## Jean Fraser - 118 condo documents- City comments

**From:** Jean Fraser  
**To:** Tom Federle  
**Date:** 4/7/2014 10:59 AM  
**Subject:** 118 condo documents- City comments  
**CC:** chip@newheightgroup.com; etheriault@e-tla.com

I refer to the ""Public Offering Statement" and various sections and exhibits that you sent to us on March 26, 2014. These are generally fine but we have a couple of comments from the Associate Corporation Counsel:

SUBDIVISION RECORDING PLAT
C1.0

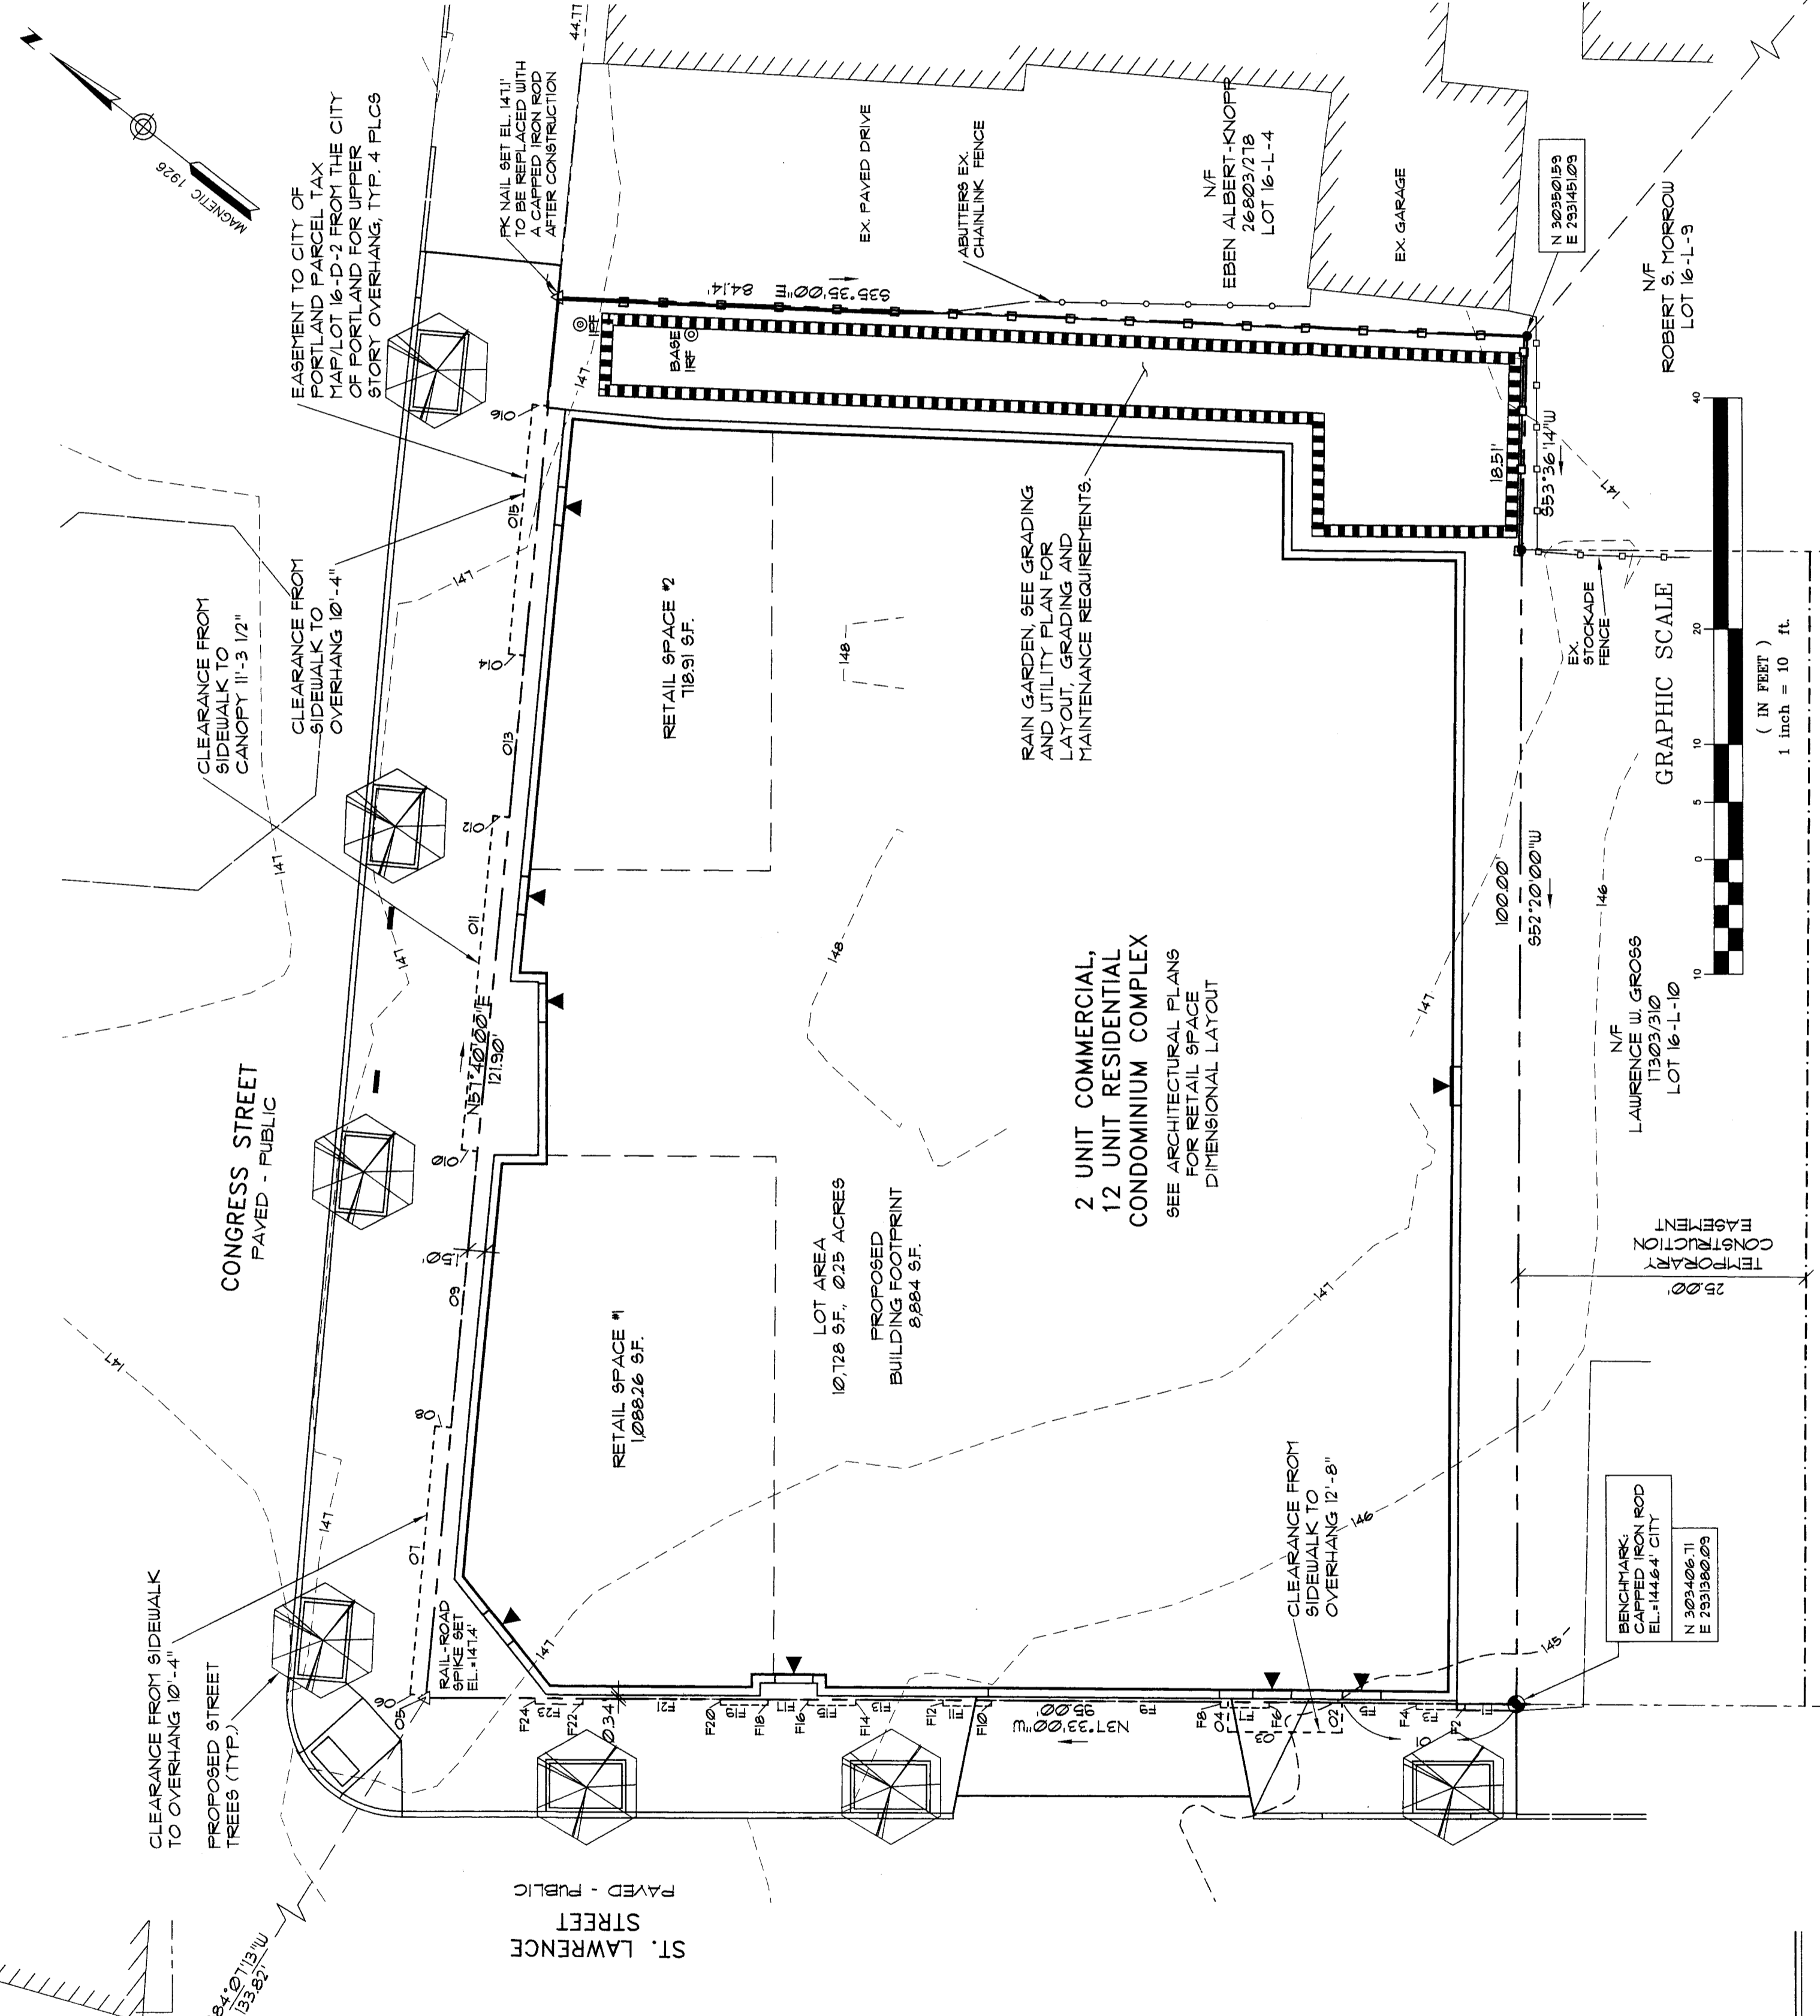
- ⌘ **Exhibit A:** Pl note earlier comment that this Subdivision Plat is a draft and should not be labelled as 'approved'. We have a number of substantive comments on the draft Plat which will be forwarded later today to Tom Greer.
